**RE: Corrected - WDFW Hwy 10 Conditional Use & Shoreline Conditional Use Permits (CU-14-00006 & SD-14-00003)**

On November 6, 2014 Kittitas County Community Development Services (CDS) received your applications for the above Conditional Use Permit (CU) and Shoreline Conditional Use Permit (SD). The application packet as submitted has been deemed **incomplete** by CDS until such time as the following are submitted:

NEW SITE PLAN

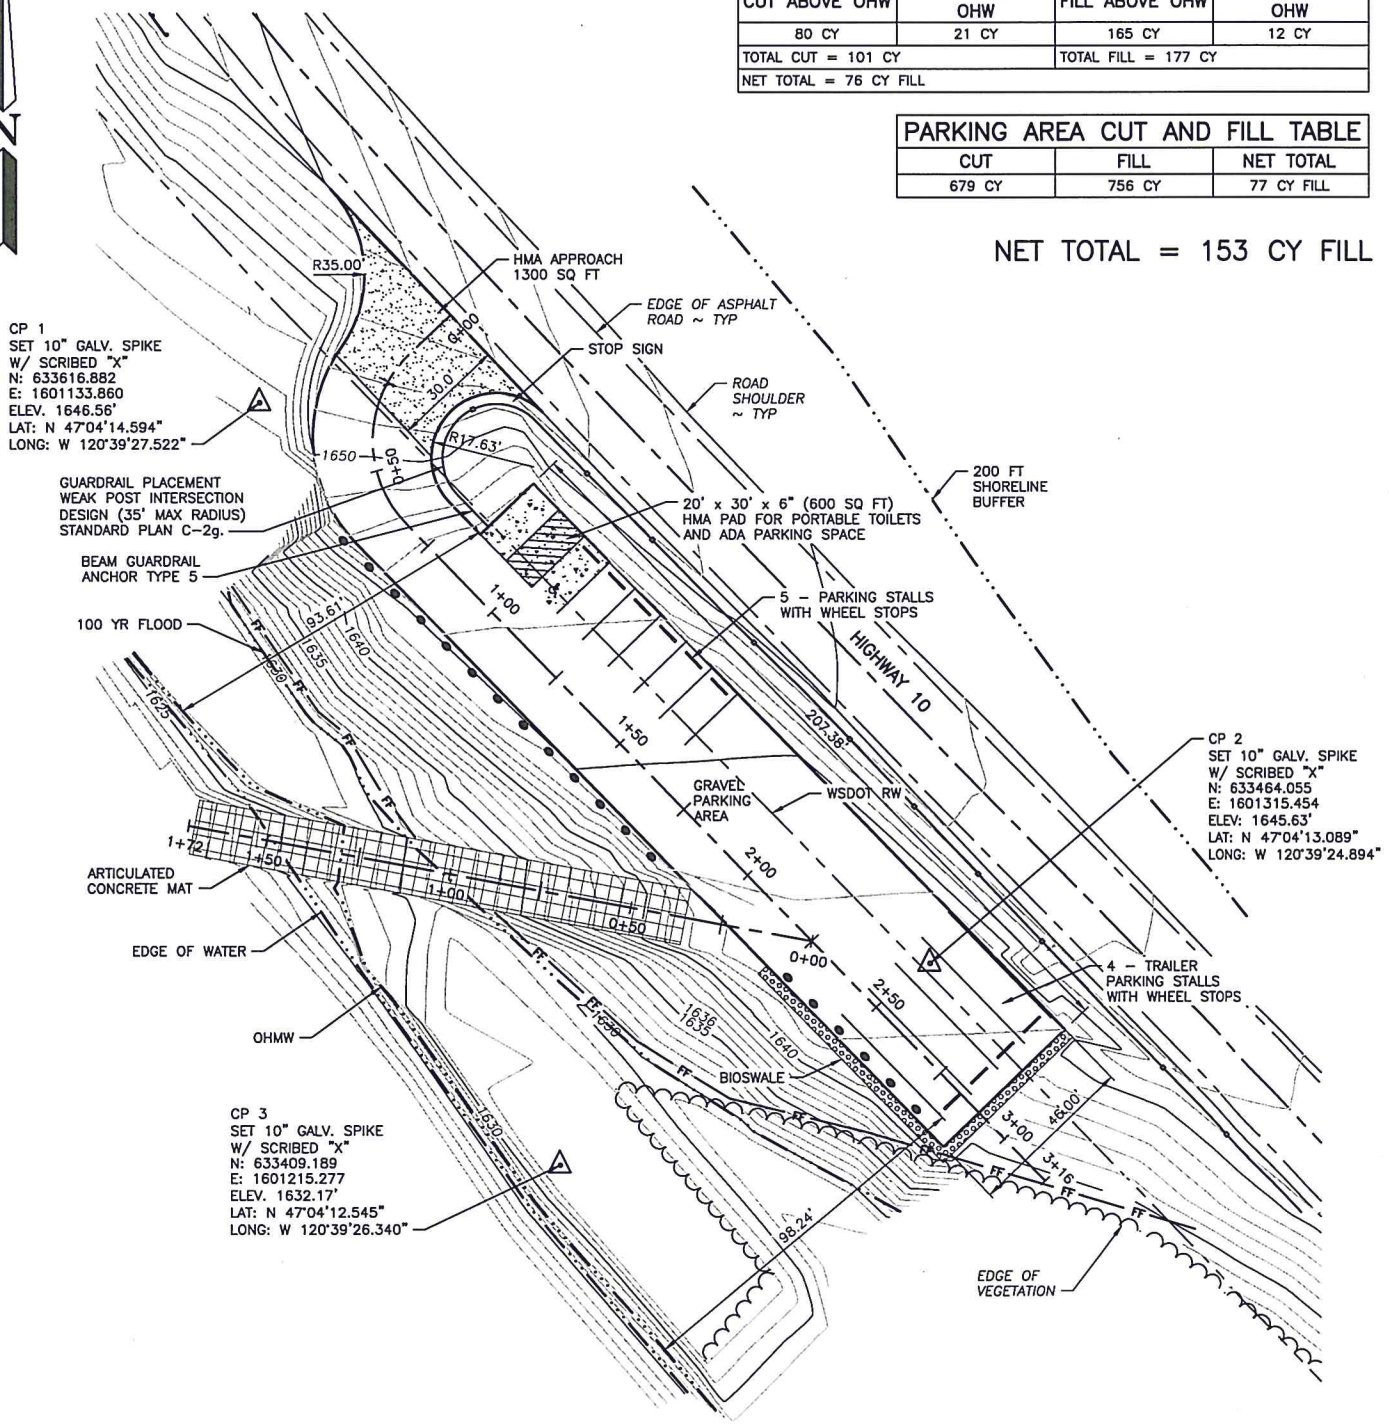
- a. *Revised site plan depicting :*
  1. Ordinary High Water Mark (OHWM);
  2. Horizontal distances from OHWM to all "structures" on the property as defined by our Shoreline Master Program;
    - a. This includes horizontal distance from OHWM to vault toilet, ADA parking spaces, standard parking spaces, and trailer parking spaces;
- b. Response to Kittitas County Code (KCC) [Chapter 17.60A.015 Questions 1-7](#).
- c. Response to Kittitas County Shoreline Master Program, Section 39: Conditional Uses (2) (a-e). This can be found on our County website at the following address:  
<http://www.co.kittitas.wa.us/uploads/documents/cds/smp/1975-Kittitas-County-SMP.pdf>
